Objection to FP/171/18/PL Erection of 18 dwellings on land at Stanhorn Grove Felpham

Objection raised by J. Boulton 23 Bridger Close Felpham PO22 8FT

Date of objection 07/08/2018

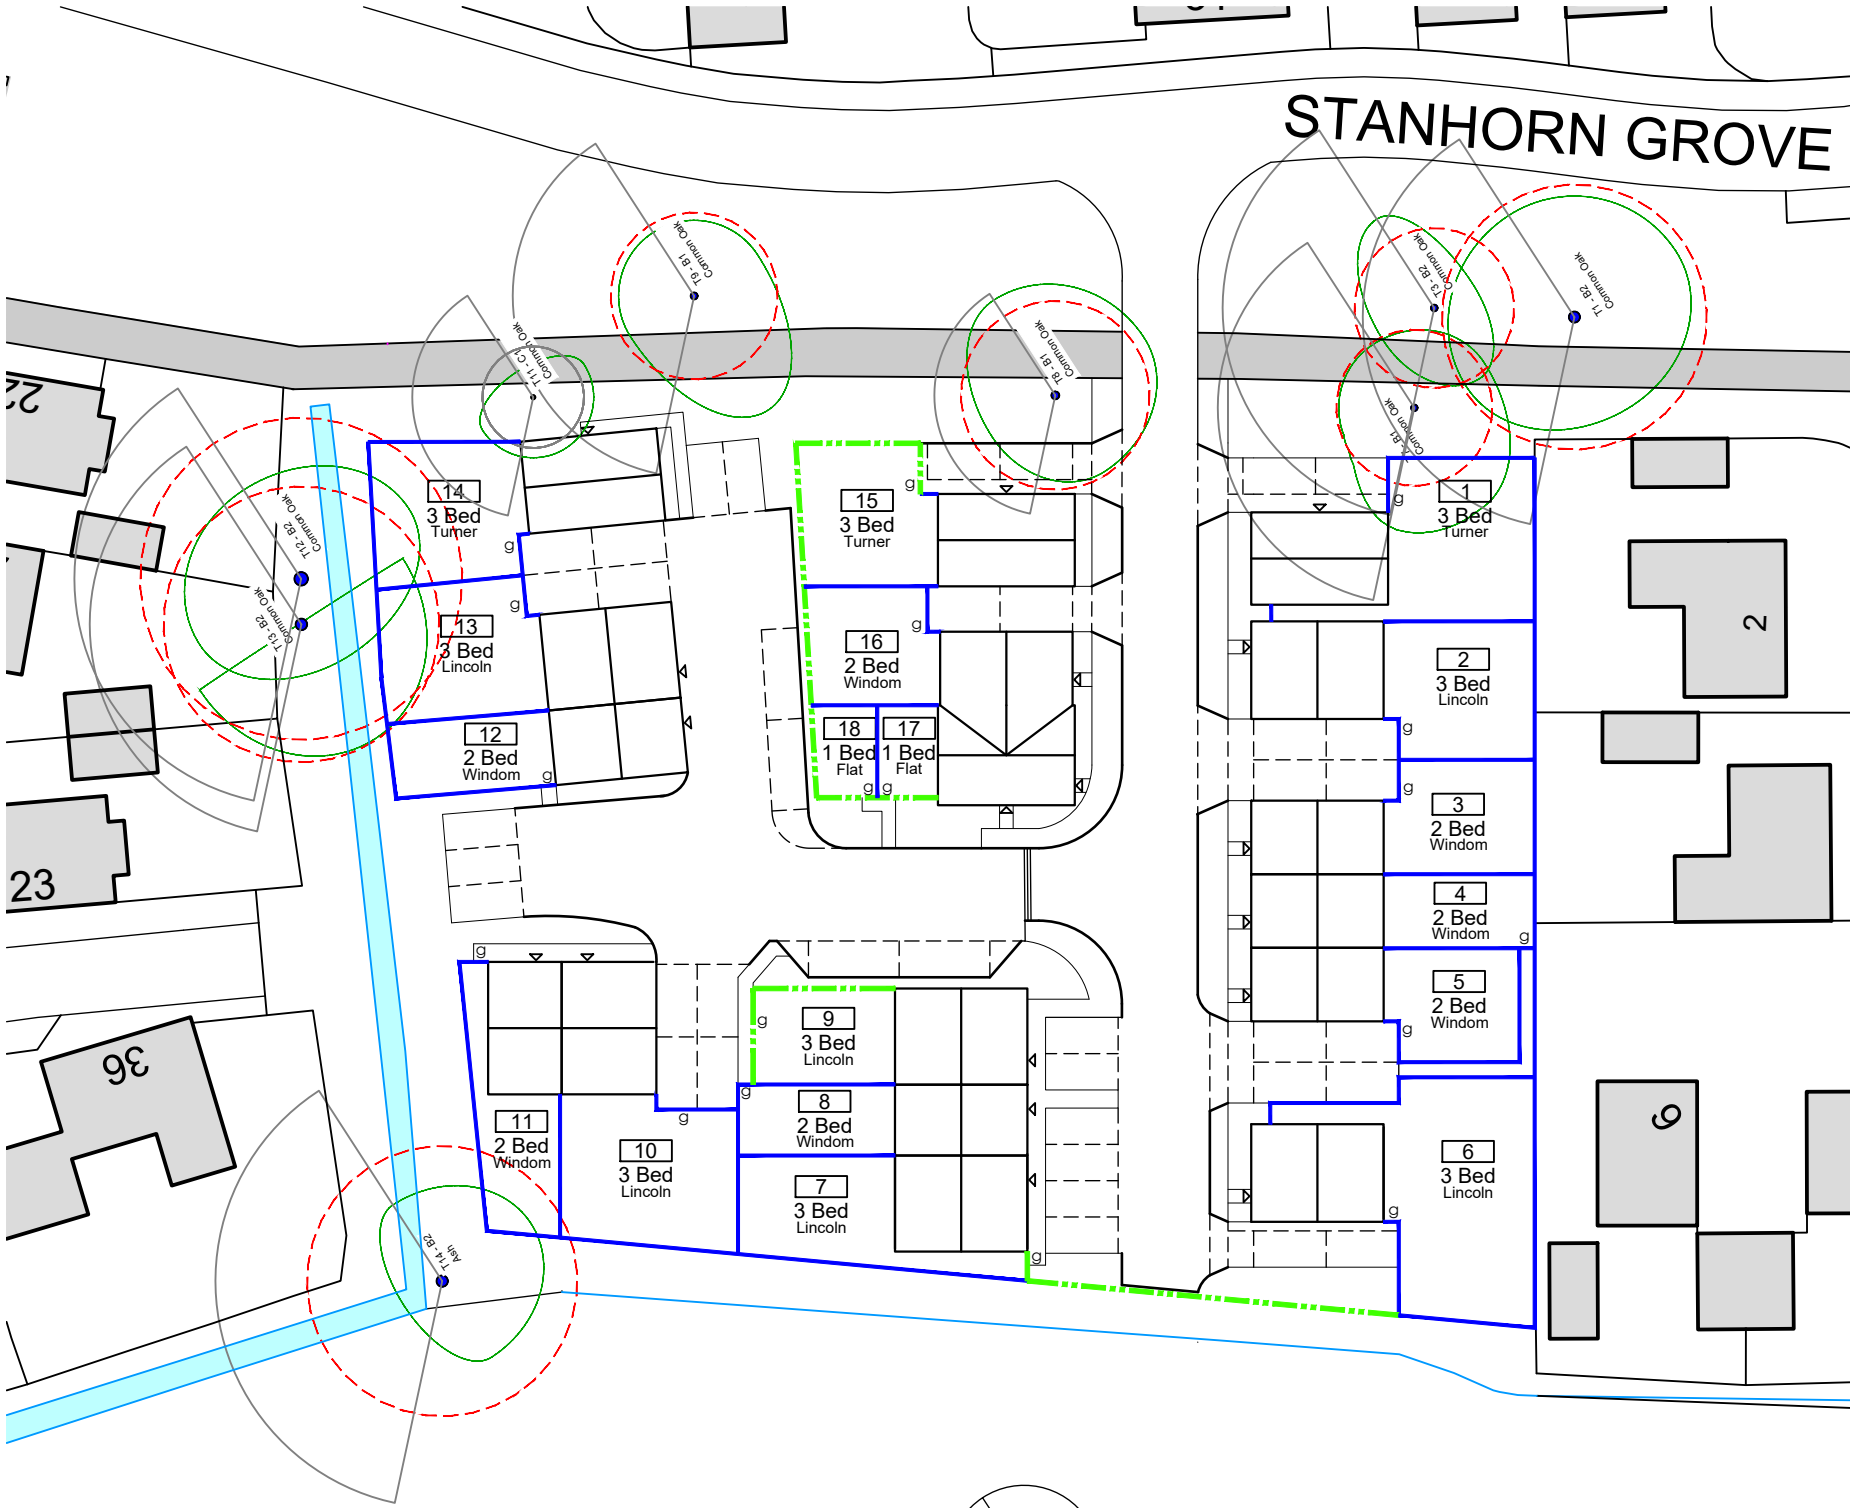
5....There are tree preservation orders on at least two trees on the perimeter of the site. Both orders have been upheld in recent tree felling applications. The plans do not appear to have taken these into account. Only one tree is shown.

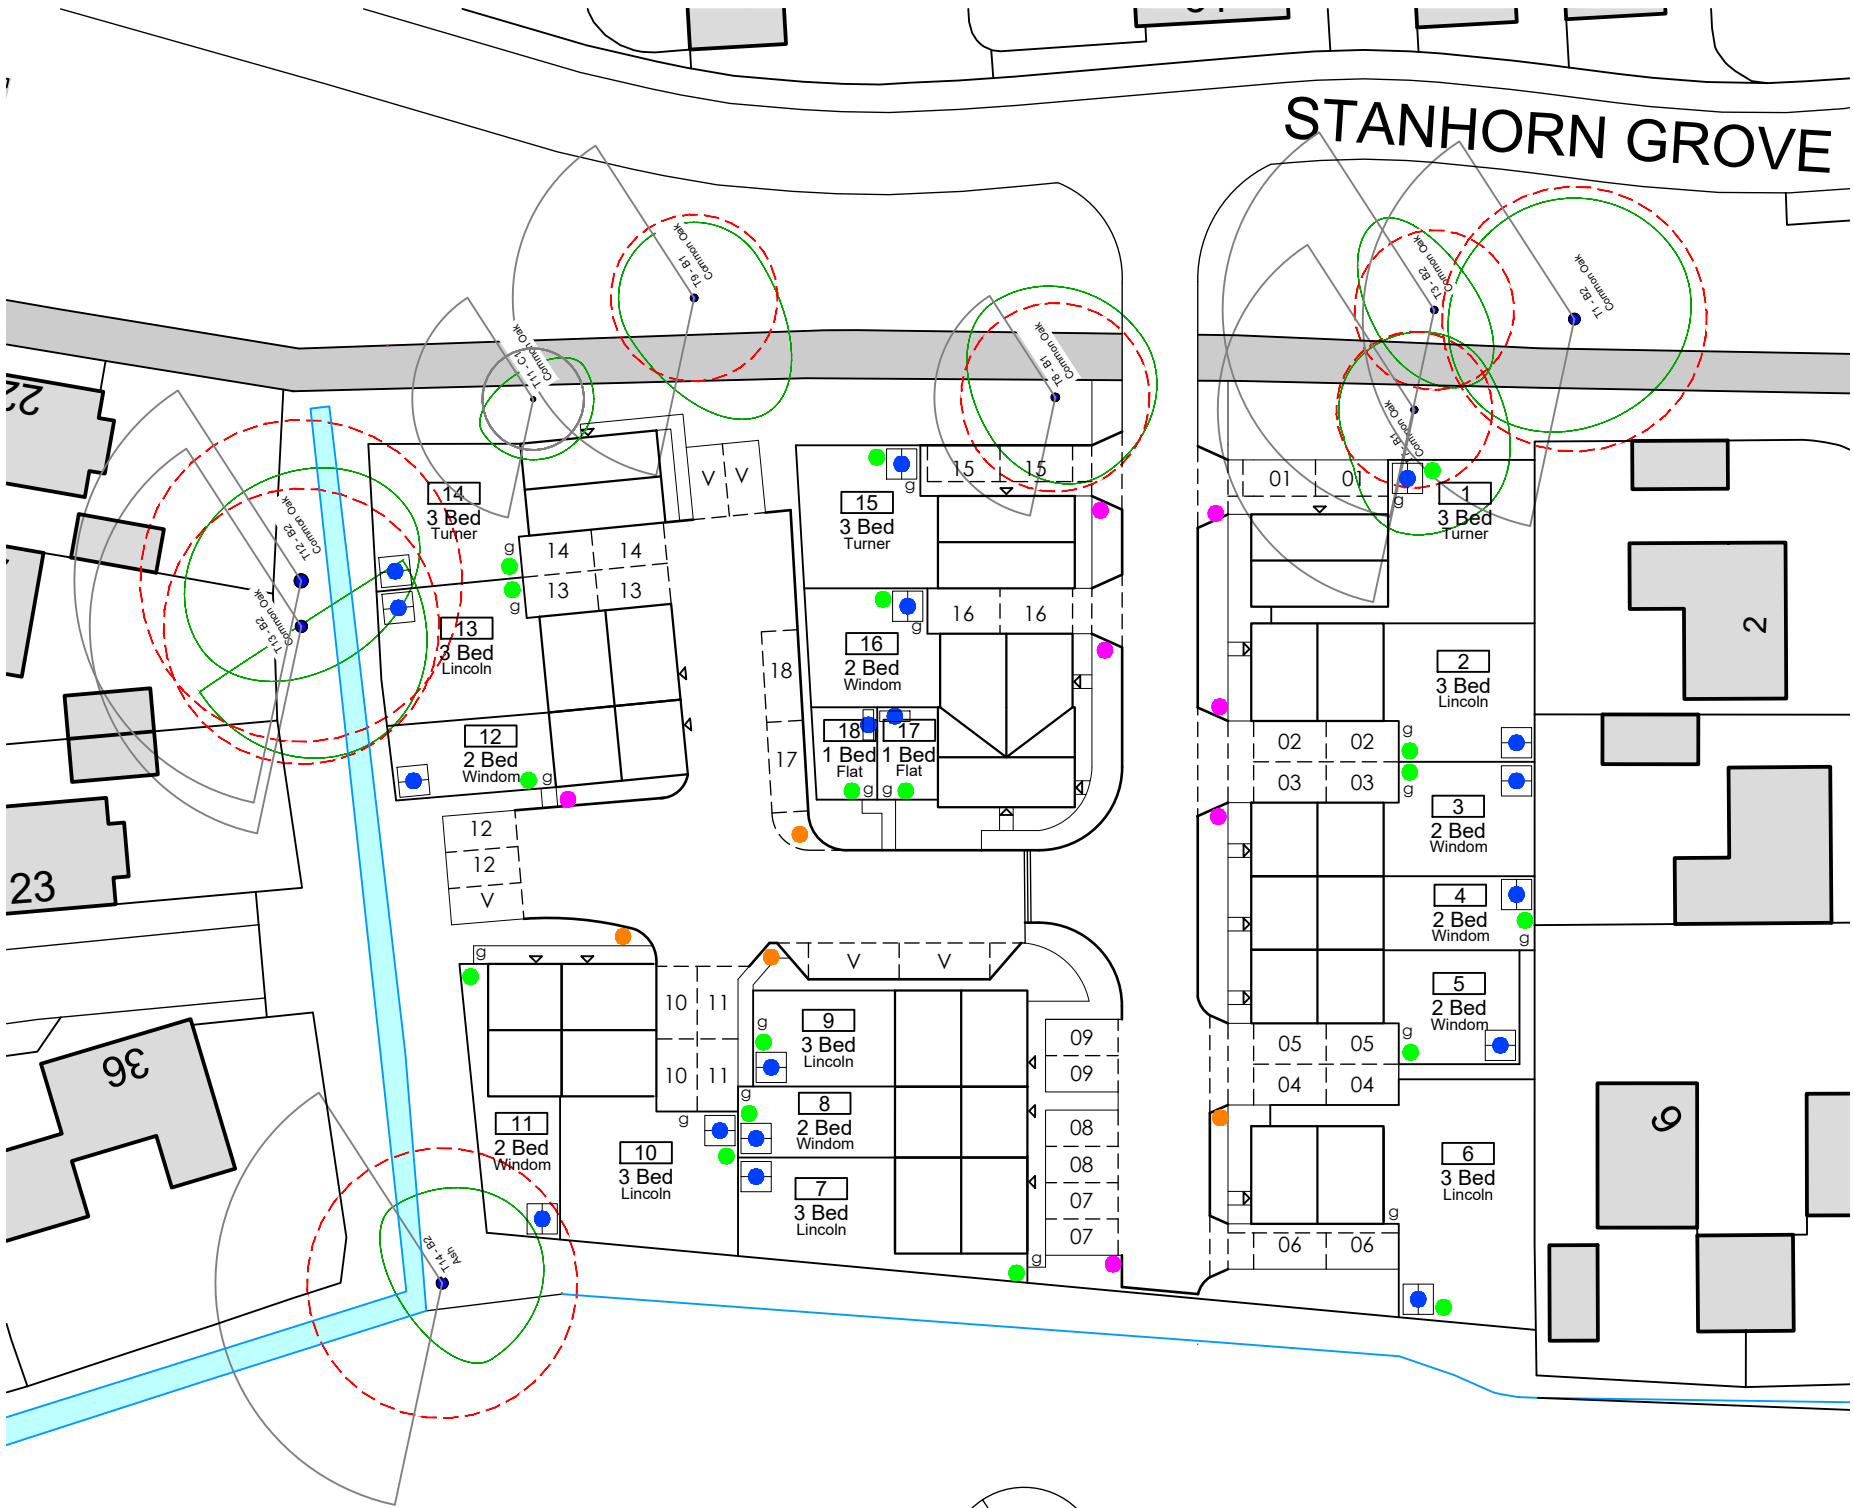
4....The proposed plans do not show sufficient space to park vehicles. There will be a need to park at least 24 cars as a minimum possibly 36. This will result in cars being parked on roads adjacent to the proposed site and result in congestion and neighbourhood unrest.
